ENG-SF22036-R1-Util-CDs.pdf Markup Summary

Subject: Callout
Page Index: 1
Date: 1/23/2023 5:14:51 PM
Author: CDurham
Color: ■
Layer:
Space:
Page Label: [1] 1 118323-TITLE-01 - Layout1

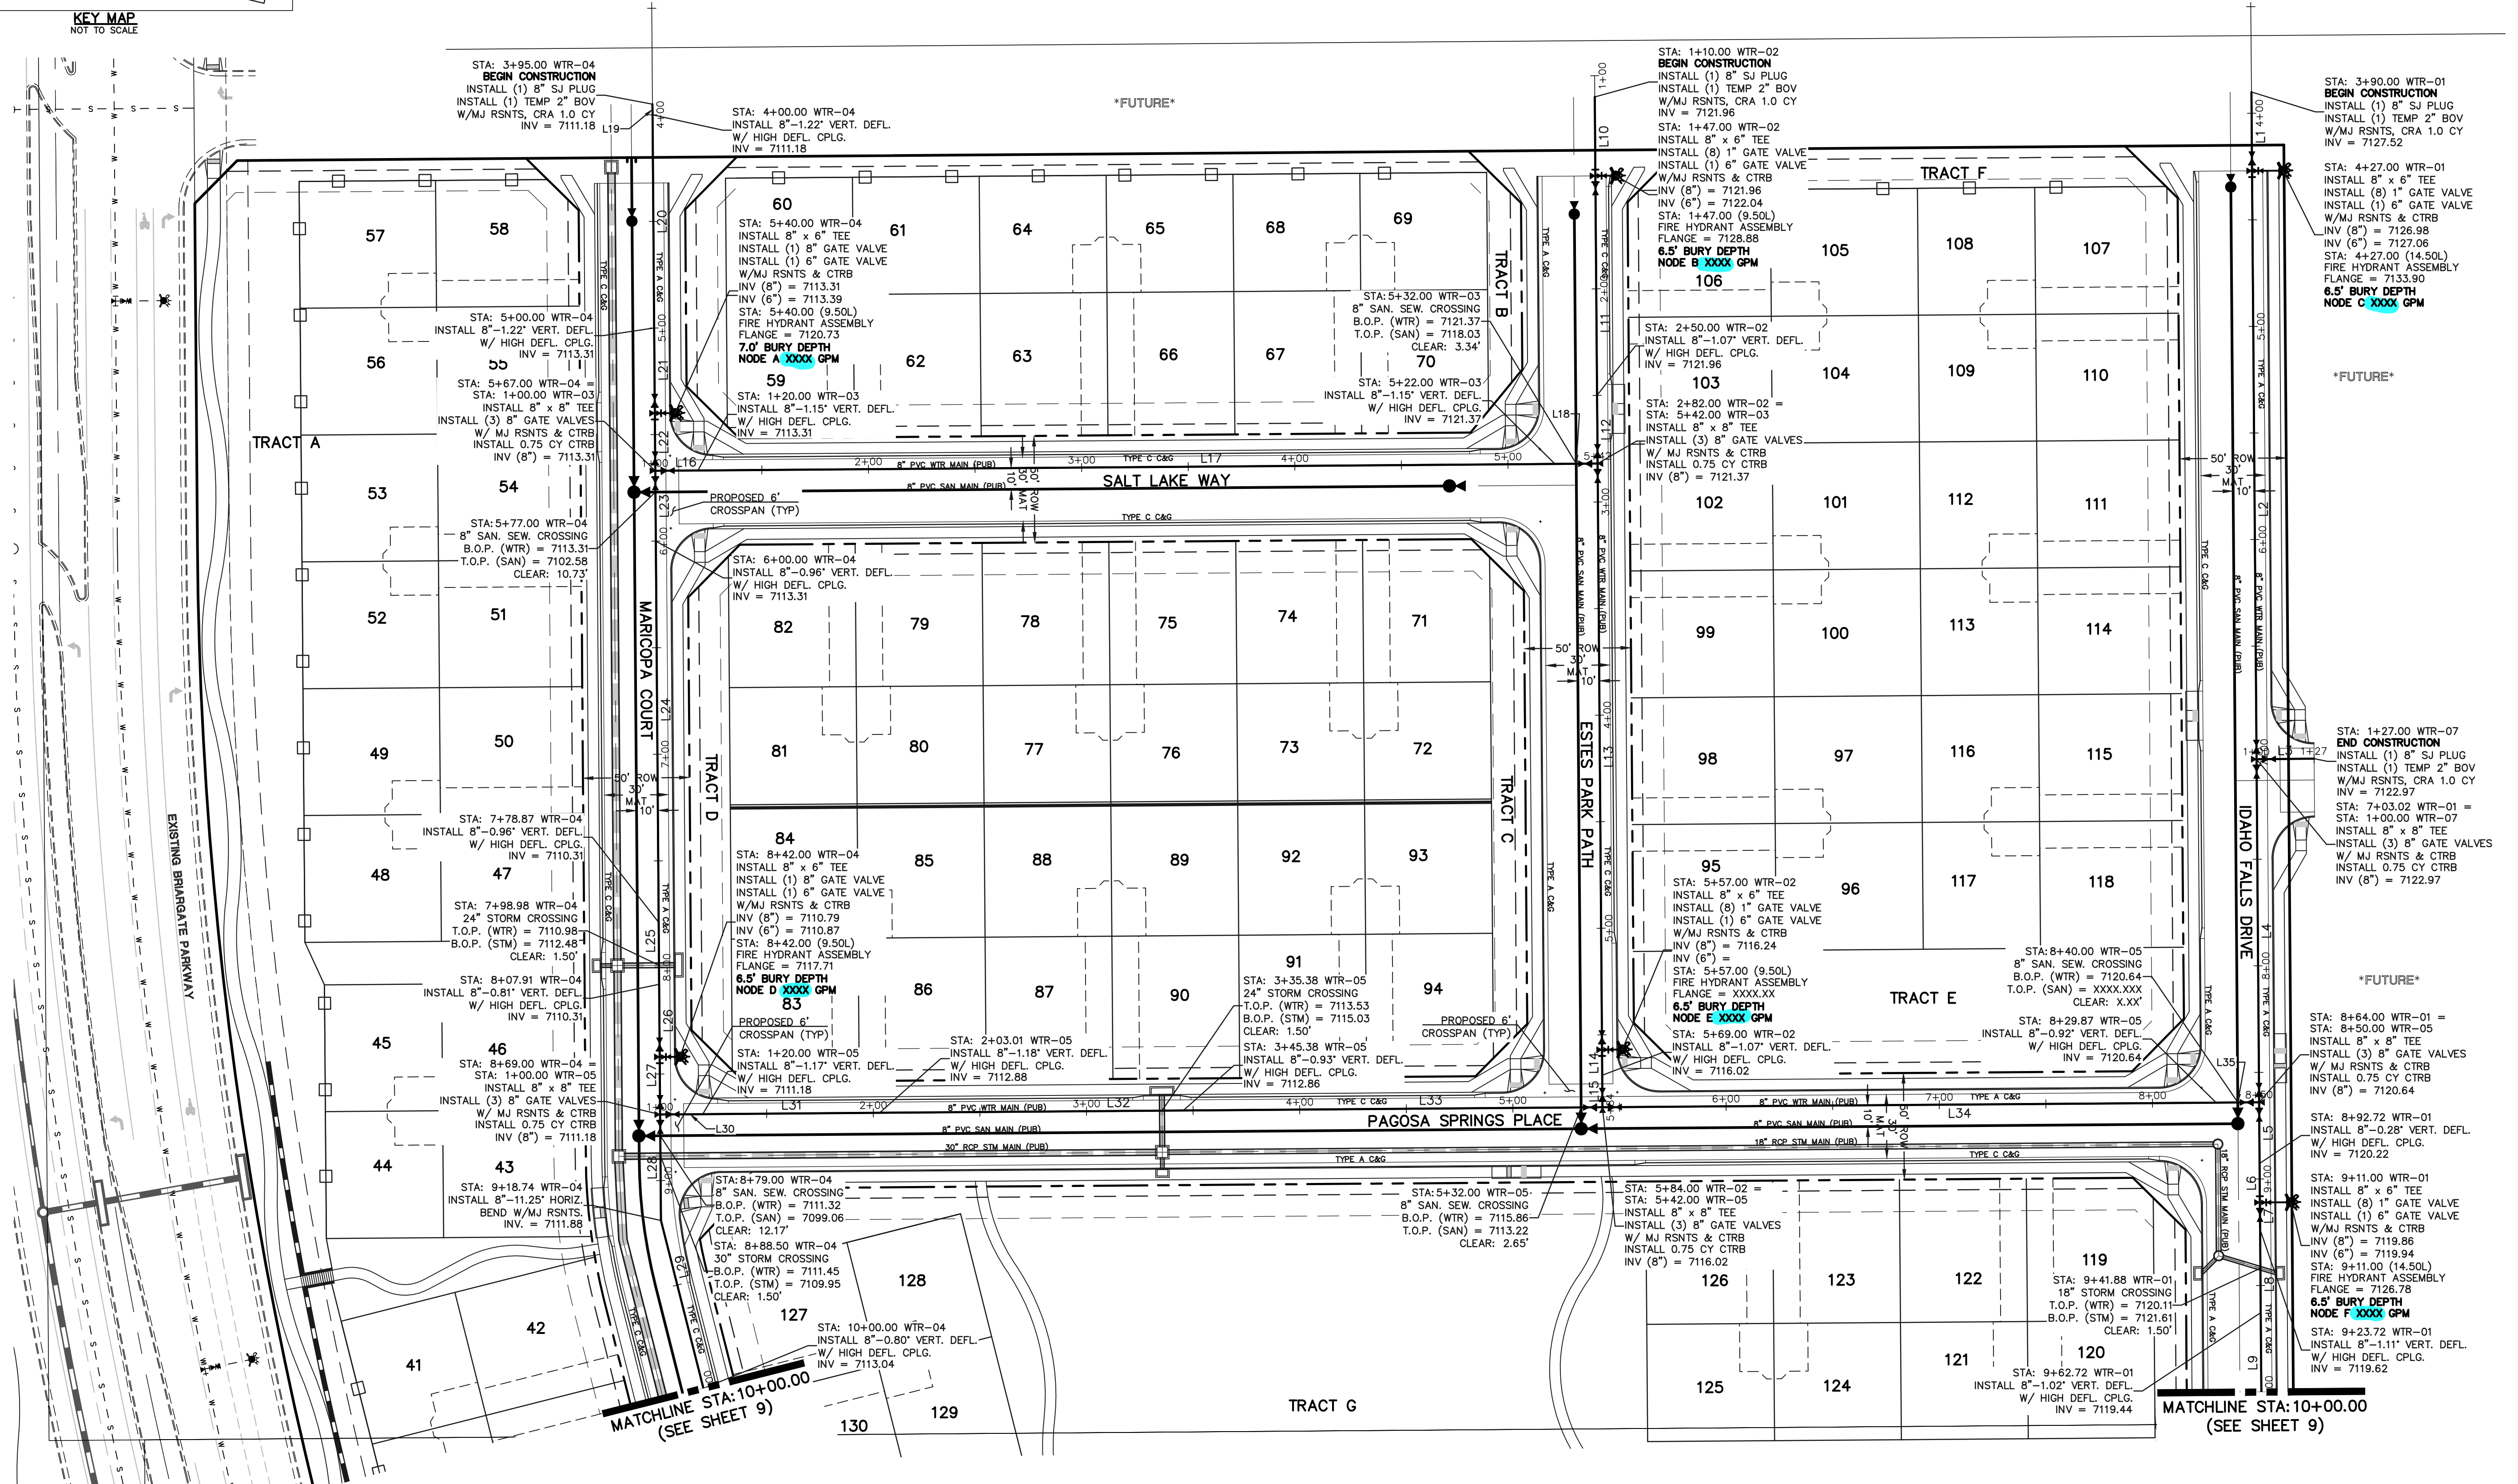
Label sizes and existing or proposed

TYPICAL FOURSQUARE PRODUCT UTILITY SERVICE DETAIL
 SCALE: 1" = 20'

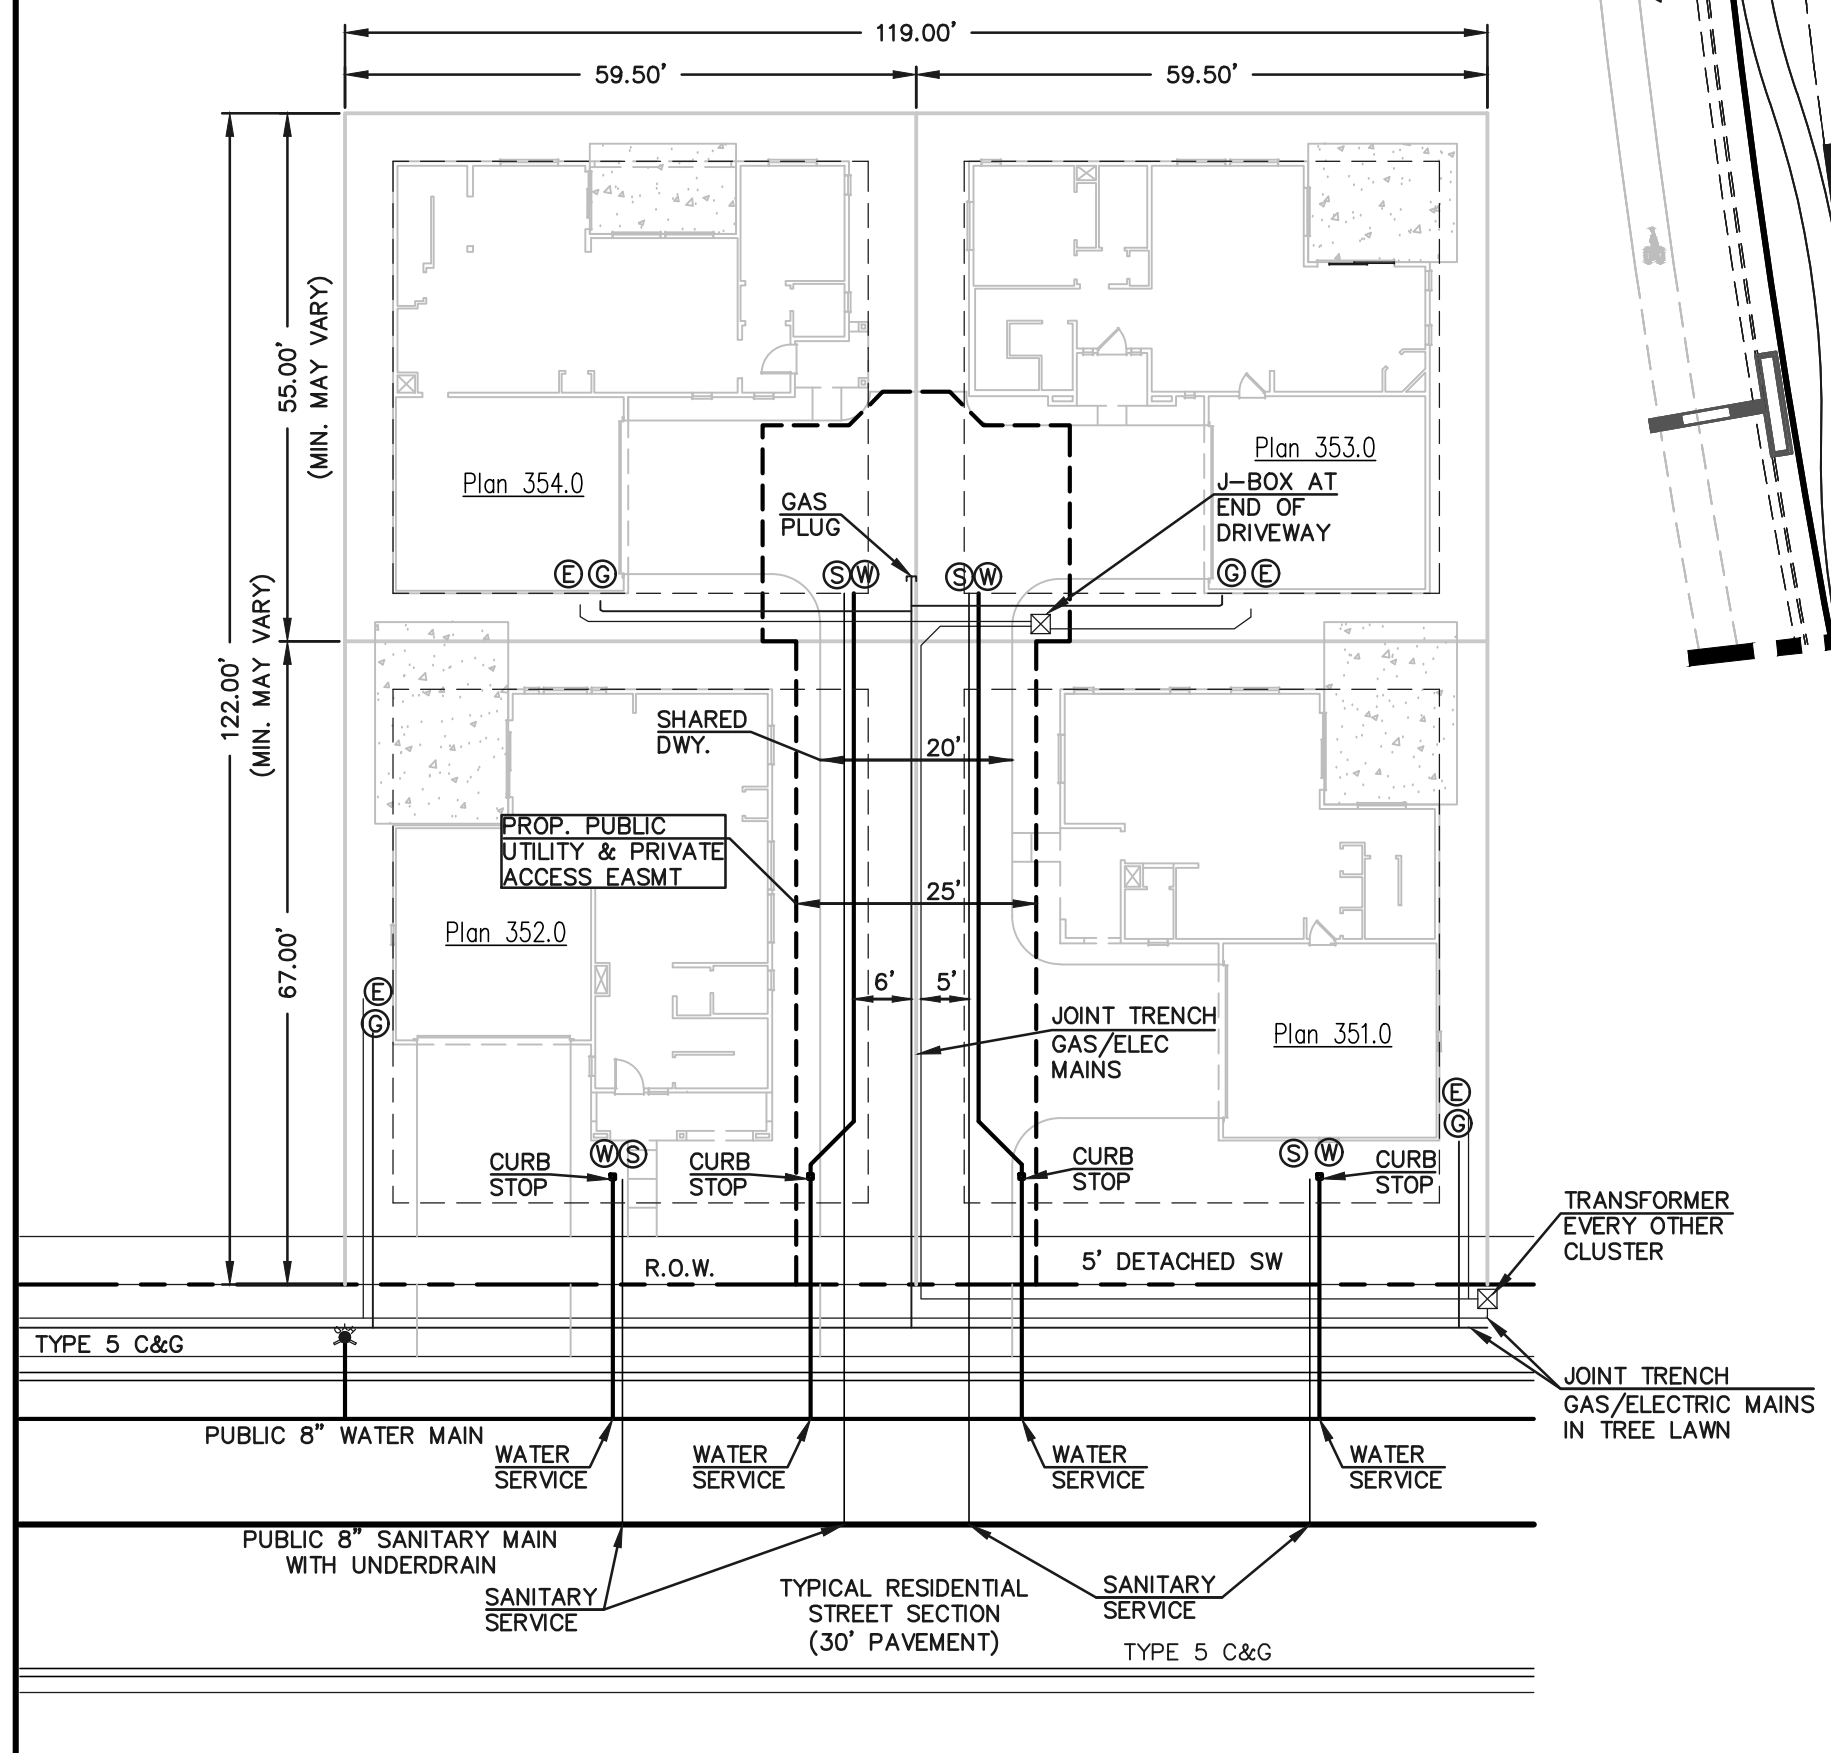
with underdrain
